**SECOND ADDENDUM LETTER TO MP09_0167
45 MACQUARIE STREET, PARRAMATTA**

This letter has been provided by JBA in relation to the V by Crown Group development at 45 Macquarie Street, Parramatta (the site). This letter has been submitted following discussions had with the Department in our meeting dated 4 May 2016, and pertains to minor remaining issues raised by the Department regarding Modification 5 to MP09_0167. In short, these issues comprise:

Basement 4

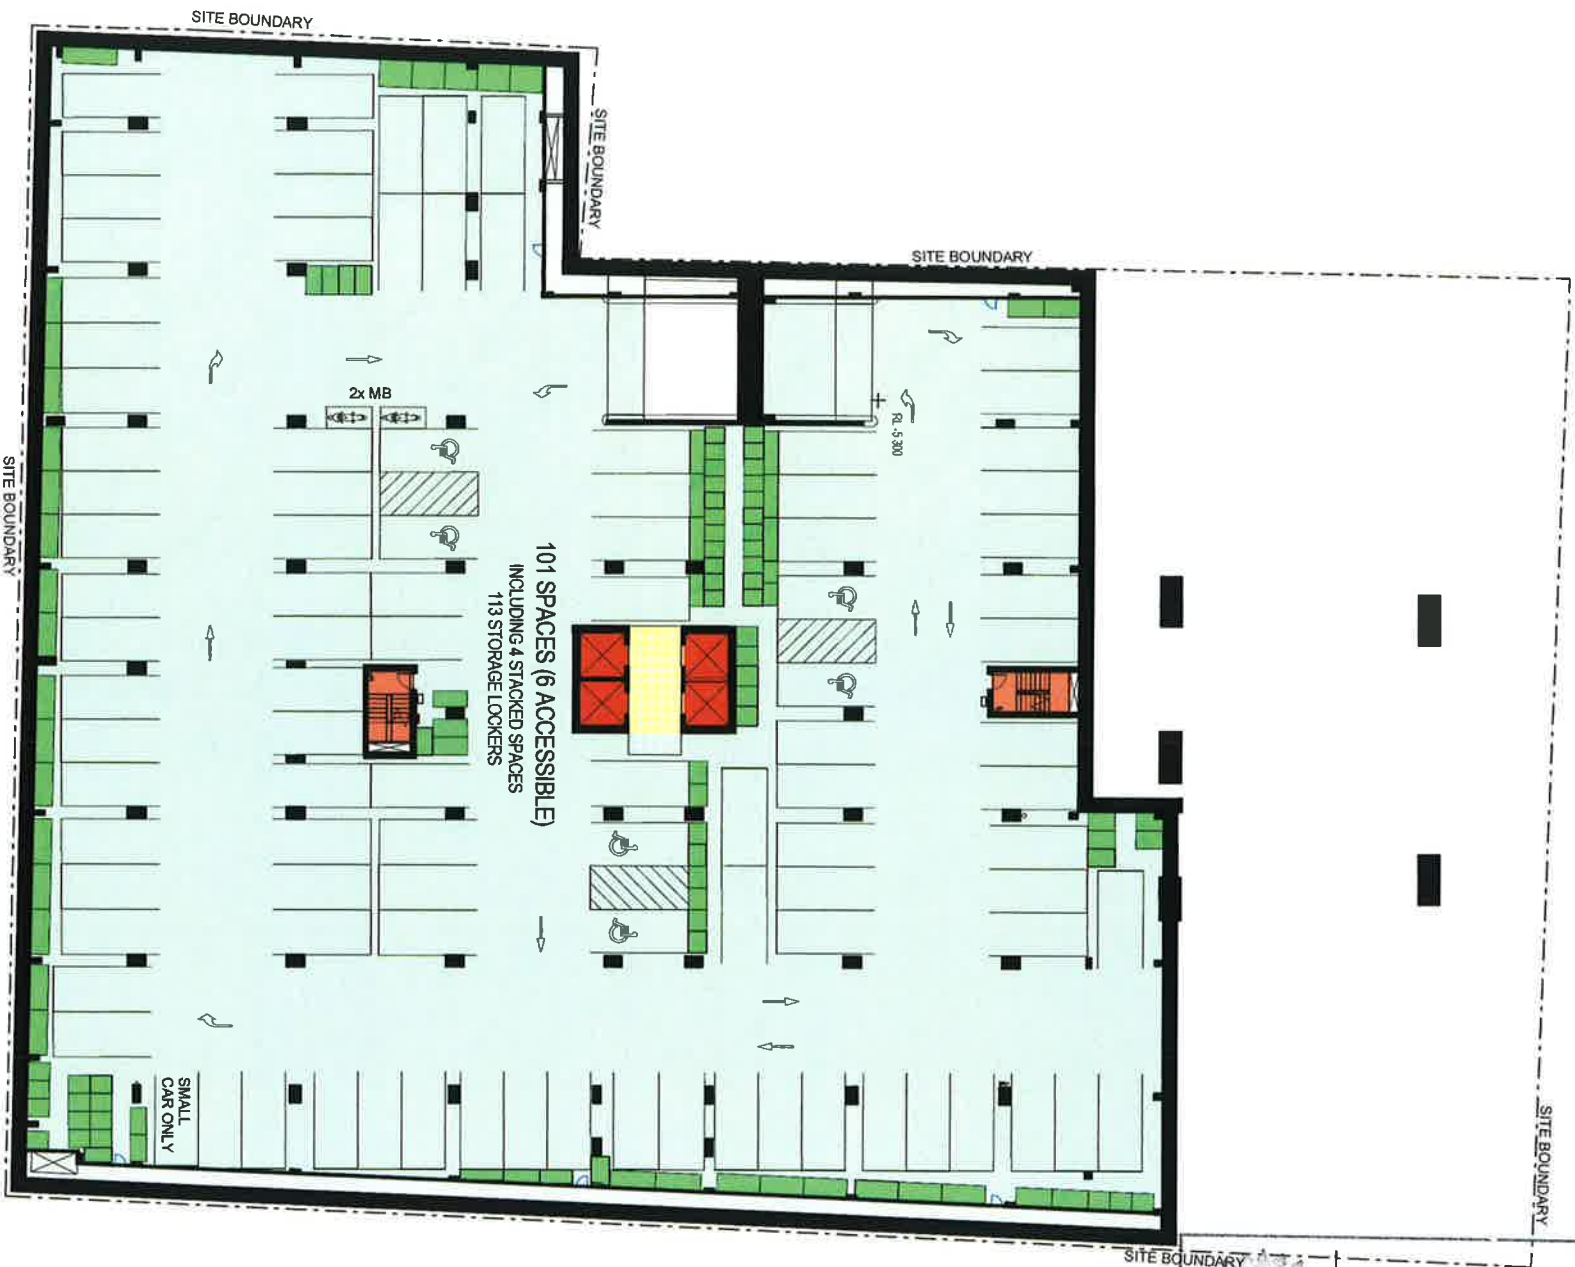
The Department has queried the necessity of changing the plans of Basement Levels 1-6, as no changes were documented in the originally submitted EAR regarding these modifications. Upon review of the amended plans, the following changes are noted as having been made for the Modification 5 Plans:

- Basement Level 1 Parking Calculations
The calculated maximum parking numbers have been amended as a result of the removal of five apartments from the amended design. No changes to the number of spaces have been proposed, with the changed figures simply to represent consistency in the maximum allowance calculations with the revised number of apartments in the Architectural package.
- Basement Level 2 Storage Rooms
Two small storage rooms have been added near the main lift lobby and at the south-eastern corner of the site.

- **All Basement Levels Bicycle Storage**
Under the previously approved plans all storage spaces required to hold a bicycle were shown in blue. This has been modified such that only bicycle spaces required to meet the requirements have been shown in blue, with additional surplus lockers shown in green. Accordingly, the proposal continues to provide the required bike parking.
- **All Basement Levels Storage Configuration**
Minor changes have been made to the location and configuration of storage containers at all levels. Important to note is that the overall quantum of storage will not be changed as a result of this reconfiguration.

None of the above changes will result in any structural changes to the basement of the V by Crown Group development, and no external impacts will arise from the proposal. Accordingly, it is requested that the changes to Condition A1 be retained within the scope of this Modification Application.

Level 29

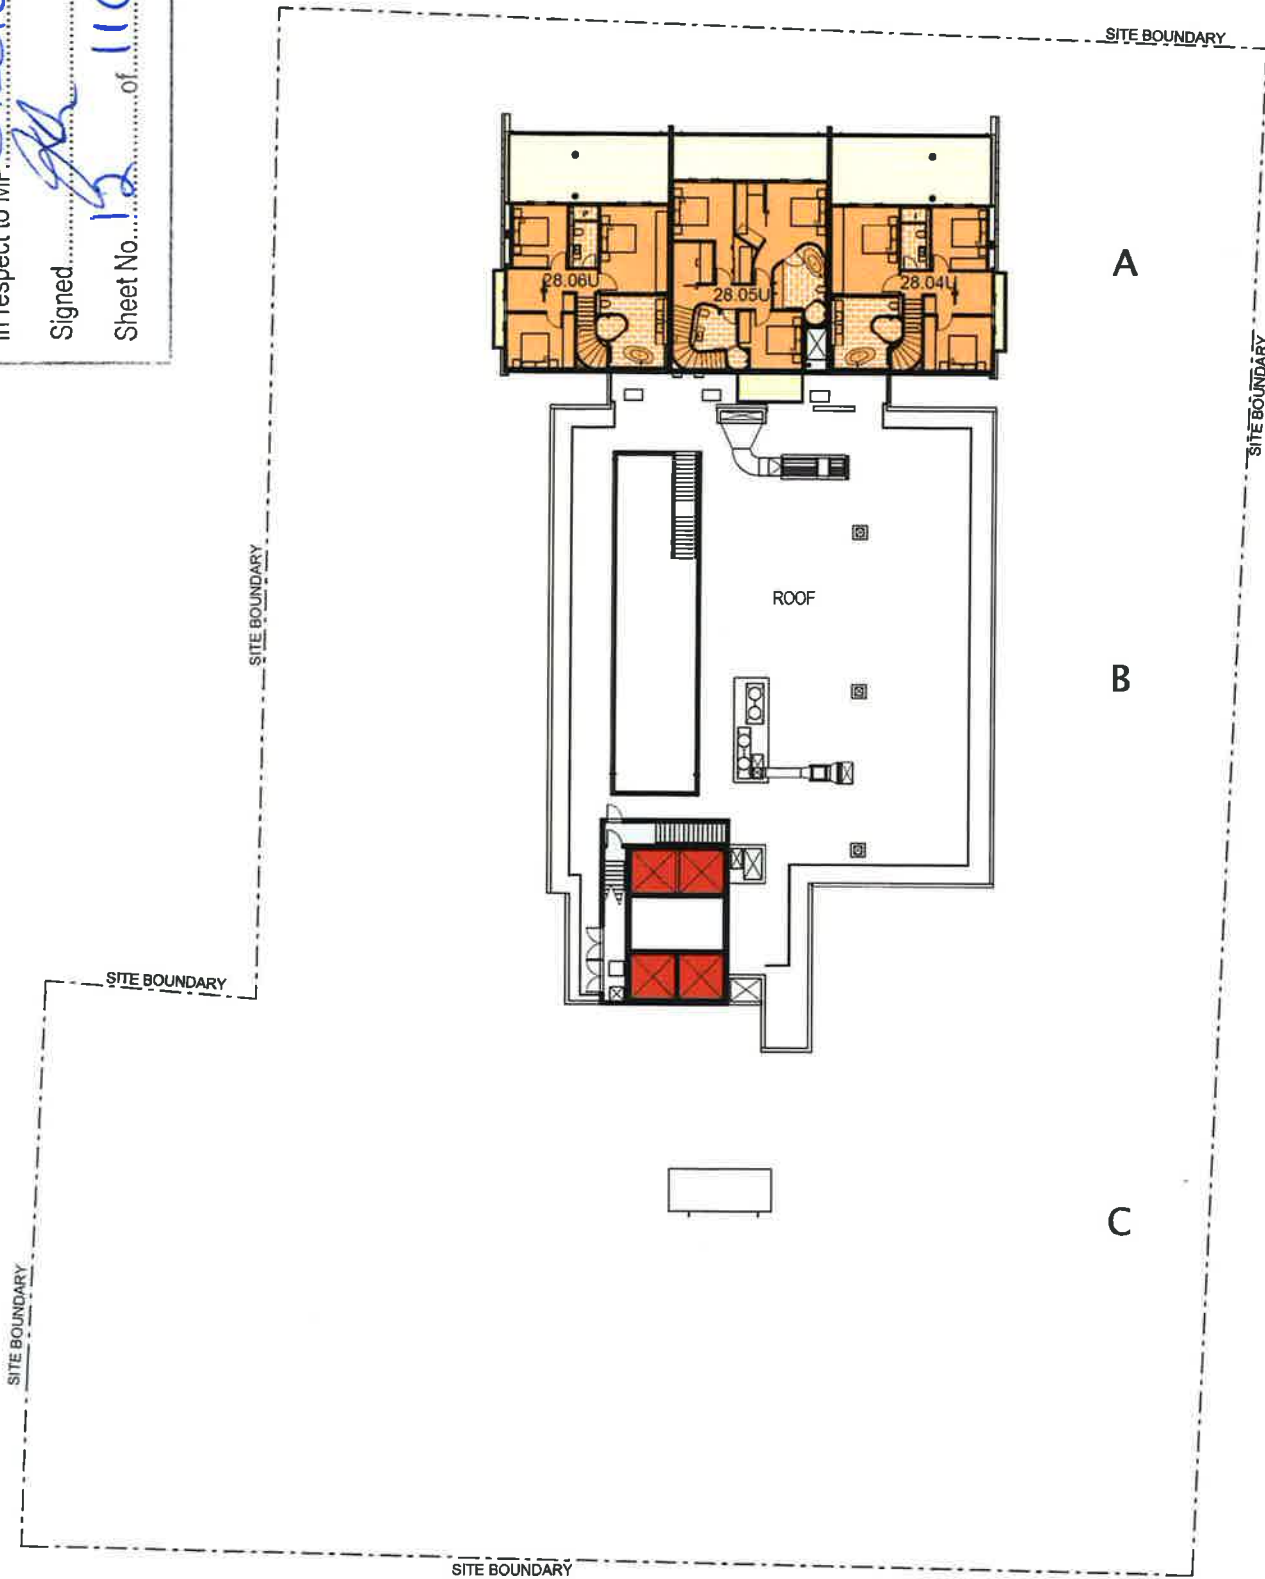
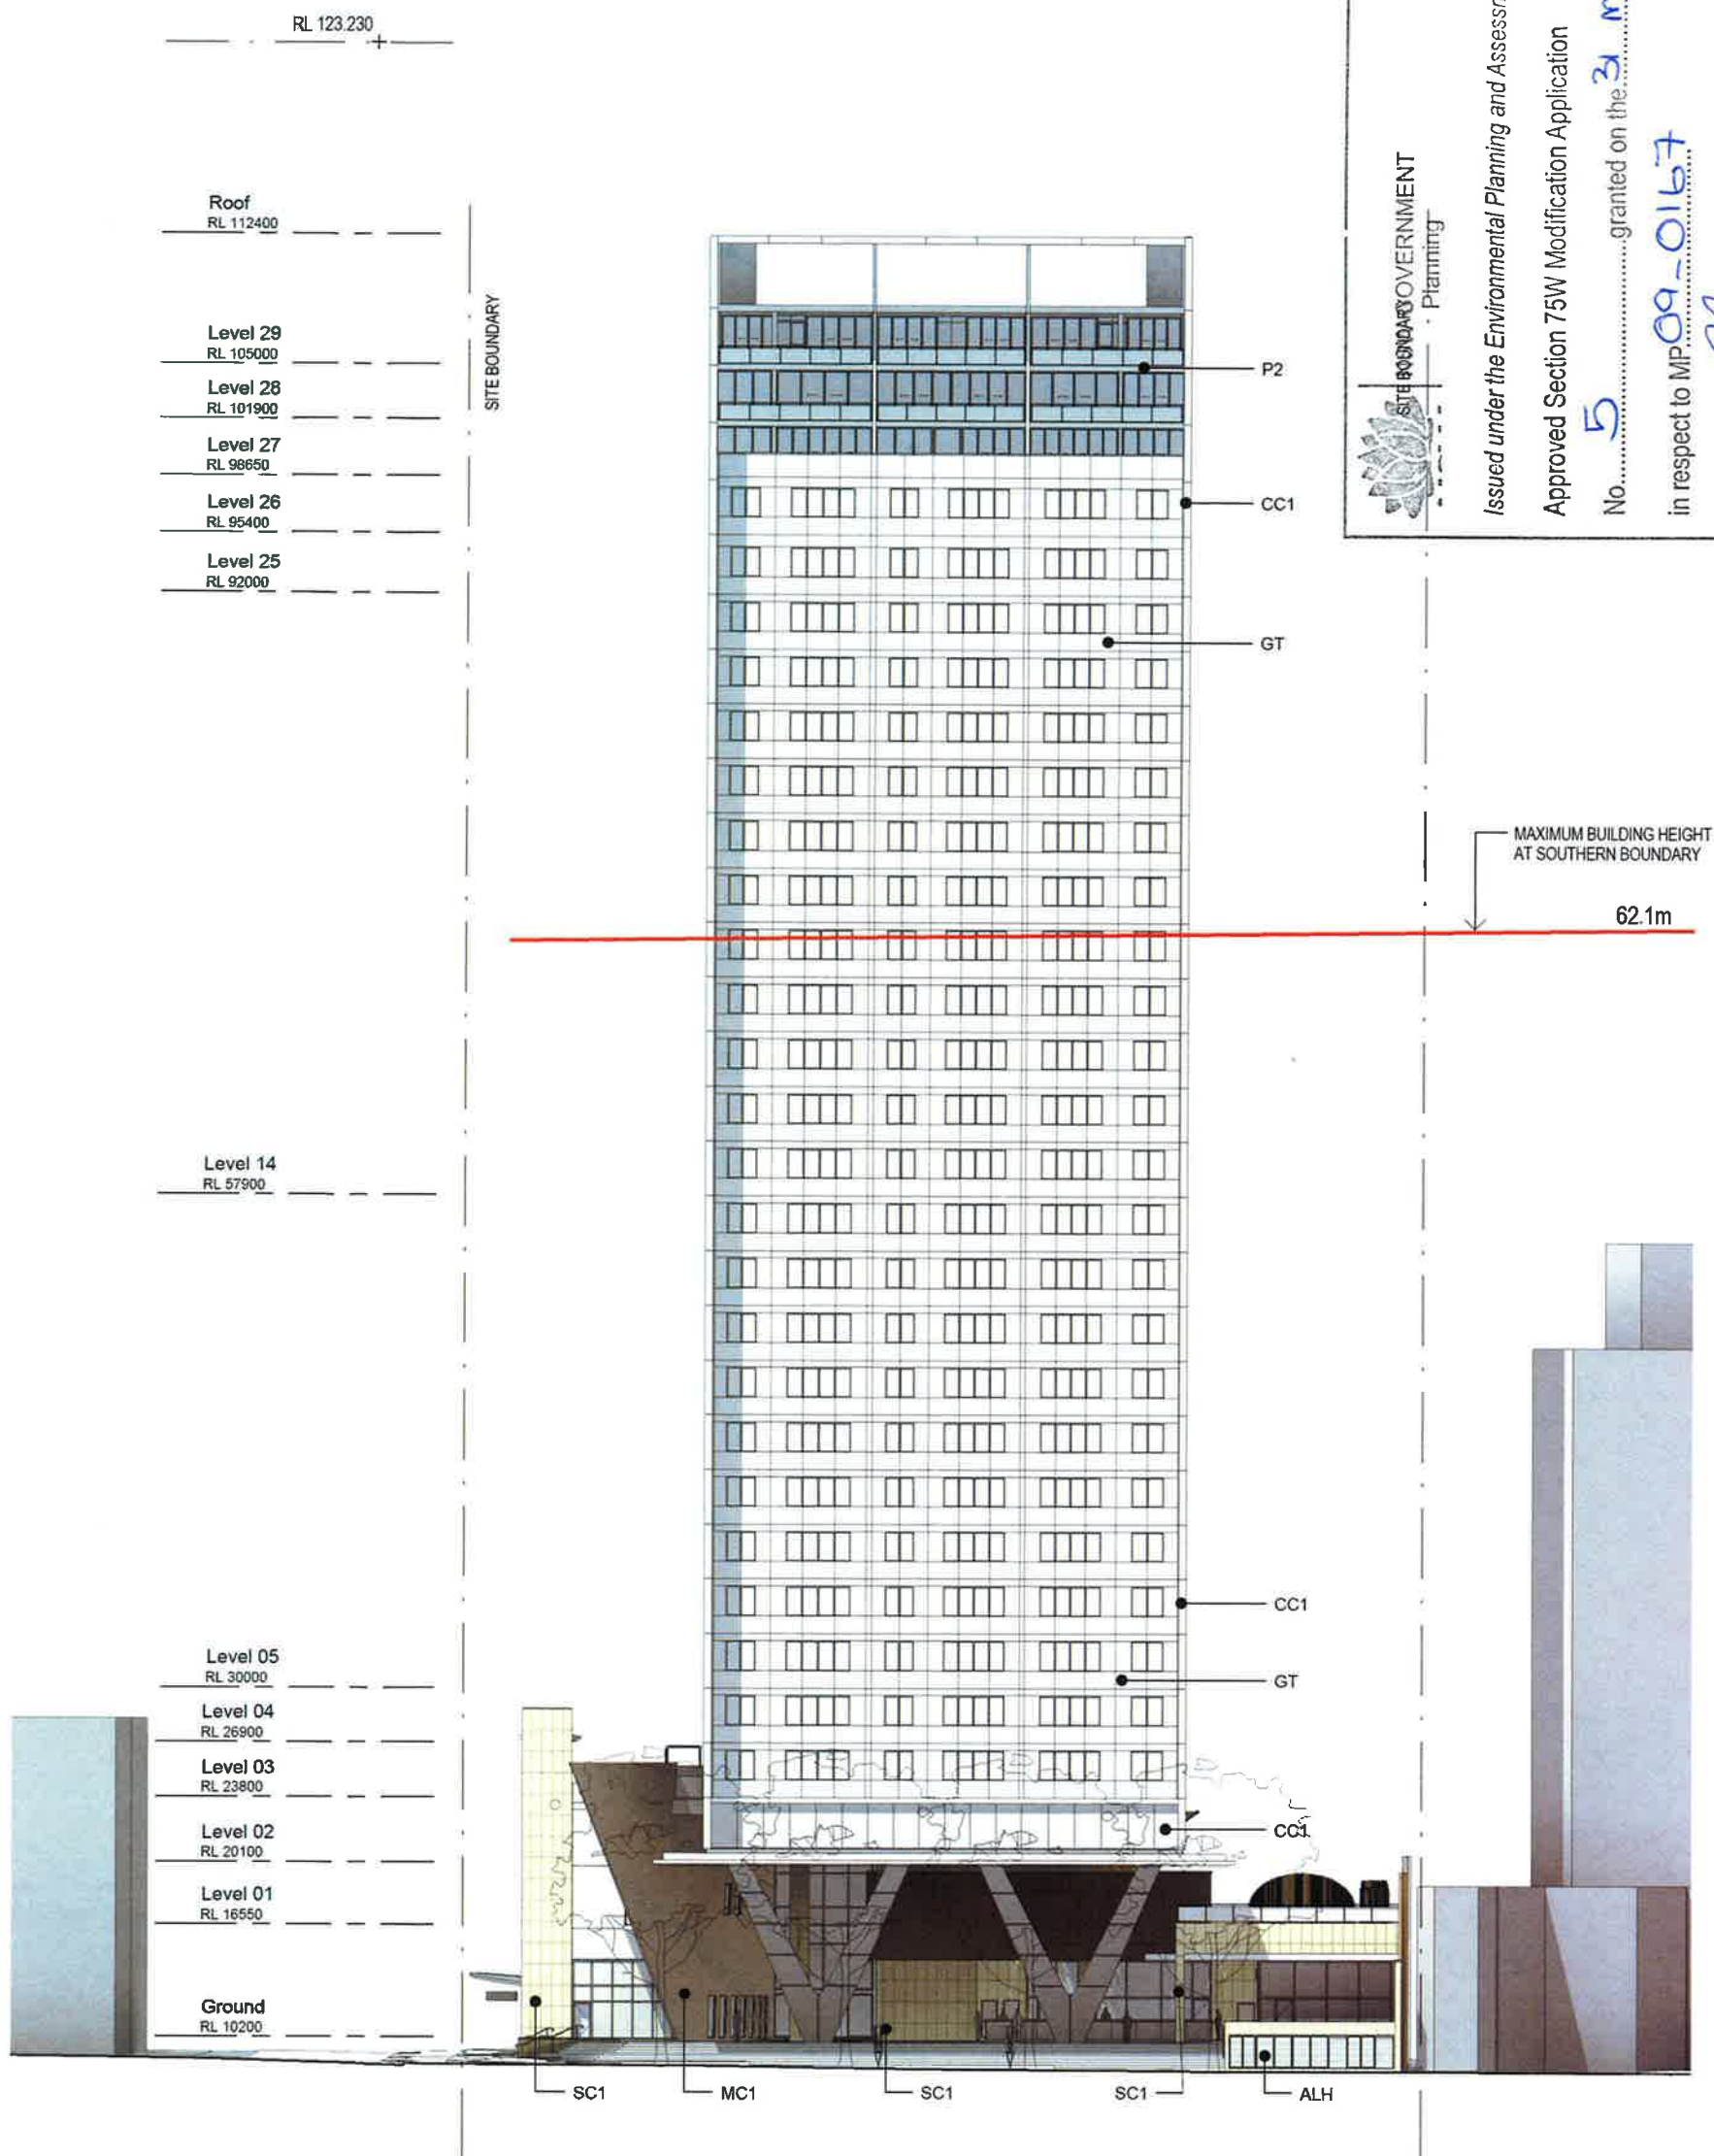
An amendment was made in the submitted plans regarding the removal of two approved lightning masts. This amendment to the design was a result of detailed design development and construction methodology, and a comparison between the approved masts and the proposed design without the masts has been produced at **Figure 1** below.

Figure 1 – Comparison of approved plans submitted under Modification 4, and submitted plans under Modification 5, demonstrating the removal of building masts.
